SUBJECT: Ellicott Gas Station  
RE: Traffic Impact Study  
Response to CDOT Comments Memorandum  
LSC #204481

Following are the LSC Transportation Consultants, Inc. responses to the January 12, 2022 CDOT Comments (posted to EDARP) regarding CS-21-002.

Ellicott Gas Station  
Traffic Impact Study Update  
PCD File No.: CS-21-002  
(LSC #204481)  
September 8, 2022

Site Plan

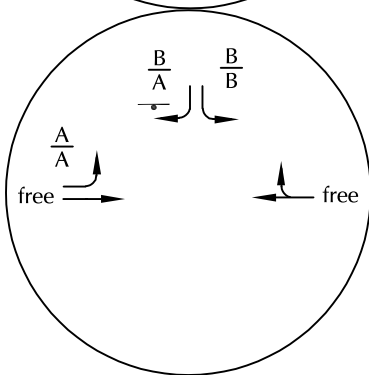
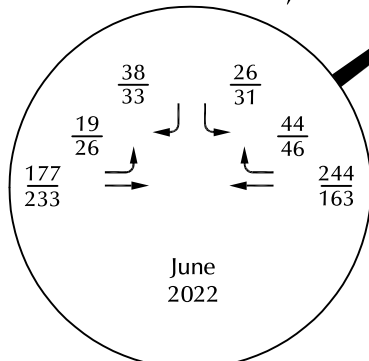
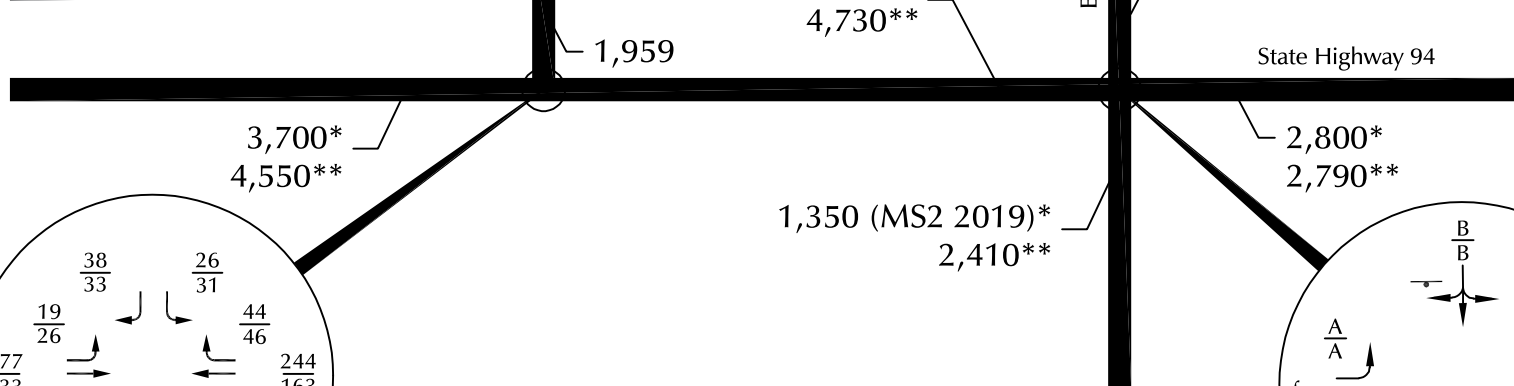
9. *The site plan provided shows a total of 4 proposed accesses: a one-way ingress next to a full movement driveway on the west side of the parcel and a one-way egress next to a full movement driveway near the east side of the parcel. Only one single point of access is allowed by the SHAC access should be allowed and only if it can meet the standards of the SHAC.*

- 13. A revised site plan with access that meets the standards of the SHAC needs to be provided.*

Reference State Highway Access Code section for access spacing and explain why comments numbers 7 and 8 on EDARP are not being met. CDOT also commented requesting one access point for both the gas station and the fire station. Revise to be compliant with their comments. If proposing on making access less than 400 feet, combine the two proposed access points into one.

Revise to provide an exhibit to show how the circulation would work and provide justification for two access points.

**LSC Response:** The site plan and proposed access plan has been revised. Please refer to the "Access Plan" section of the TIS and Figure 2, which depicts a proposed access reconfiguration plan.

**LSC Response: The site plan and proposed access plan has been revised. Please refer to the “Access Plan” section of the TIS and Figure 2, which depicts a proposed access reconfiguration plan.**

The combined gas station and fire district building existing access point is currently about 165' wide, the west edge of which is about 440 feet west of the centerline of the SH 94/Ellicott Highway intersection. The revised site plan shows a proposed new west edge of the gas station access at 375 feet west of the centerline of the SH 94/Ellicott Highway intersection. The plan shows the access width for the gas station narrowed to 40 feet. The centerline spacing from SH 94/Ellicott Highway intersection would be 355 feet. The plan shows the proposed reconfiguration of the wide access for the gas station and a separate access for the fire district centered on the front of the fire station. The plan shows separate fire district access point because placement of the gas station access to allow for trucks to enter, circulate within, and exit the gas station site would create a more difficult and cumbersome ingress and egress for the storage building.

Please refer to notes on Figure 2 regarding the proposed access reconfiguration plan.

Figure 7
 Existing + Additional/Expansion-
 Generated Site Traffic, Lane
 Geometry, Traffic Control, and LOS

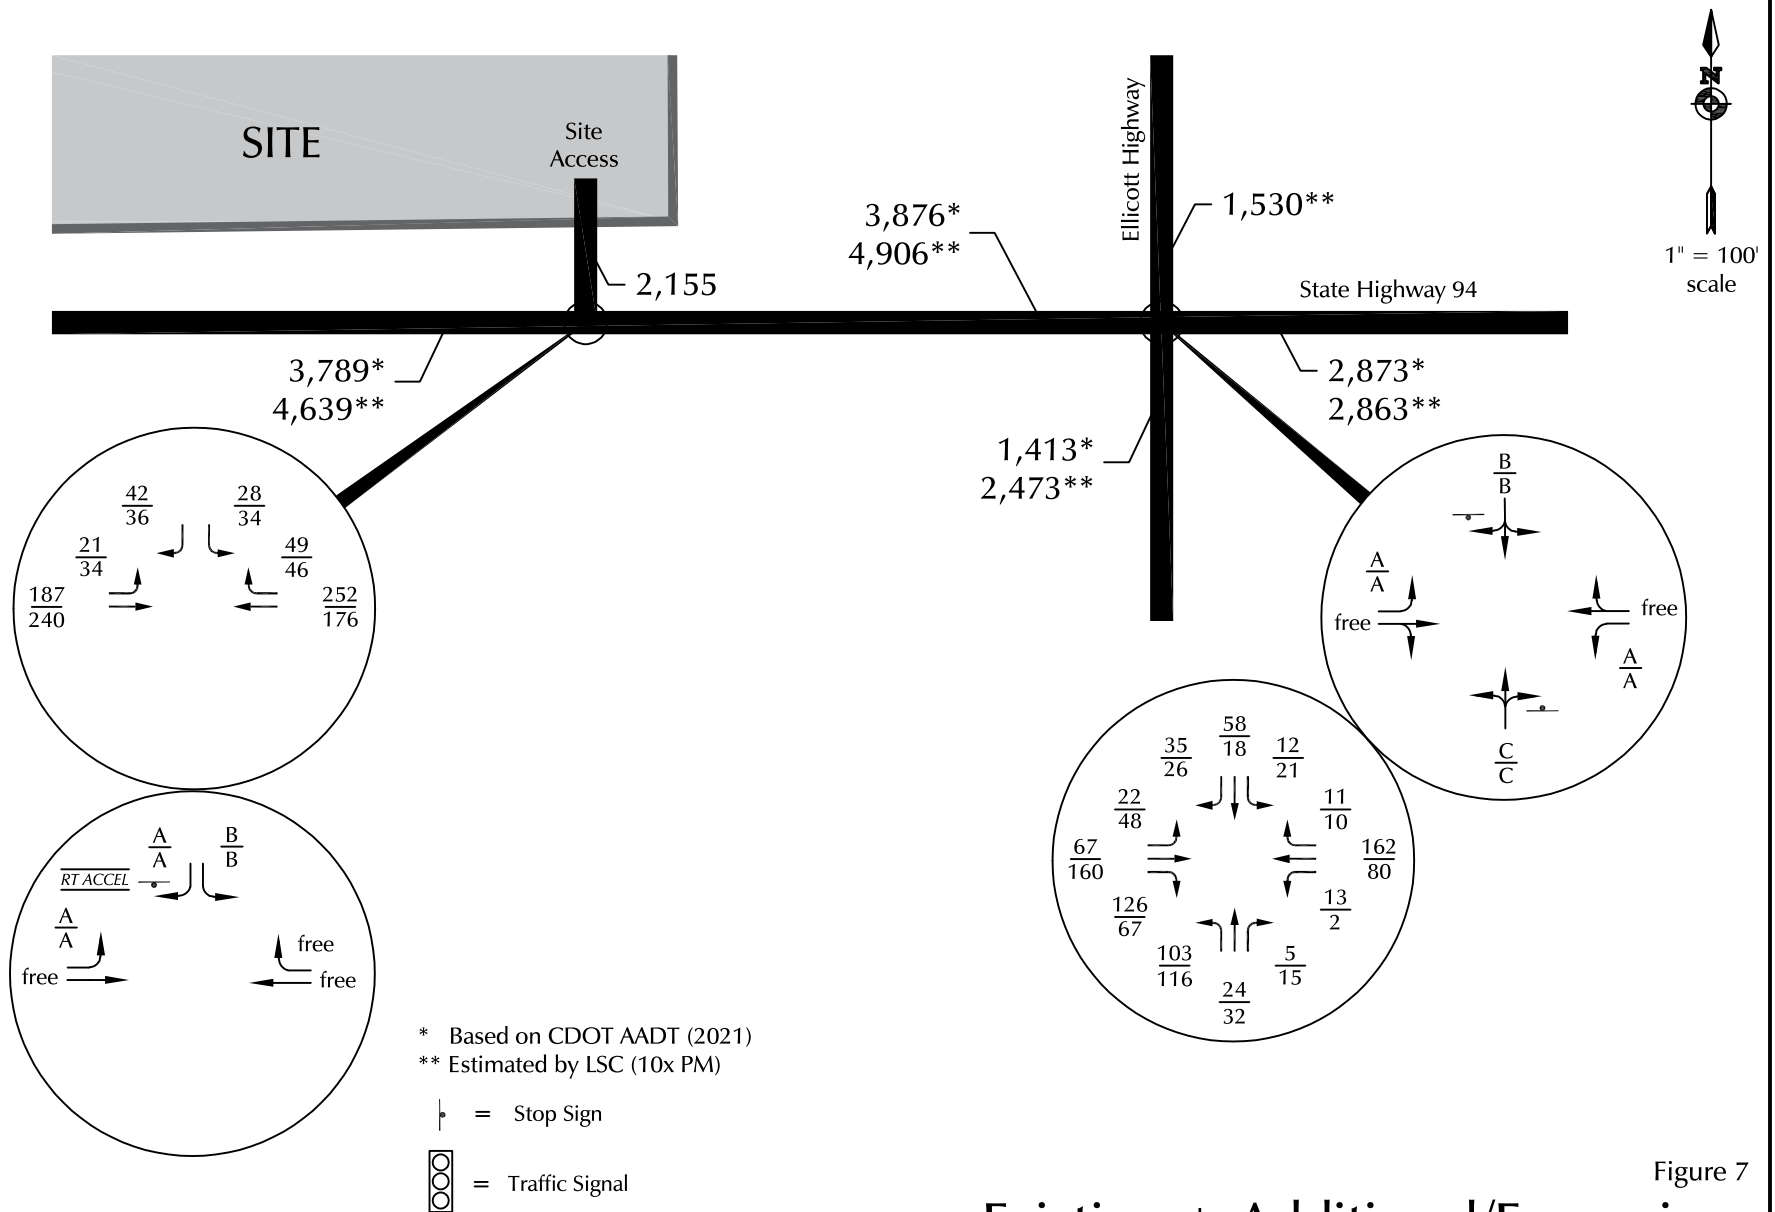
10. *Per the Hwy 94 Access Management Plan, the intersection of SH94 and Ellicott Highway is identified for signalization in the future. The TIS should analyze the impacts of queue lengths and other operational components of a future signal. Left turning outbound trucks would have to wait for a gap in westbound traffic generated by a future signal at the Ellicott Highway and then may be prevented from doing so due to a queue of eastbound traffic stopped at the signal.*

**LSC Response:** This comment has been addressed in the updated report. A queuing analysis has been added. Also, see the note on Figure 2 regarding the gas station access location.
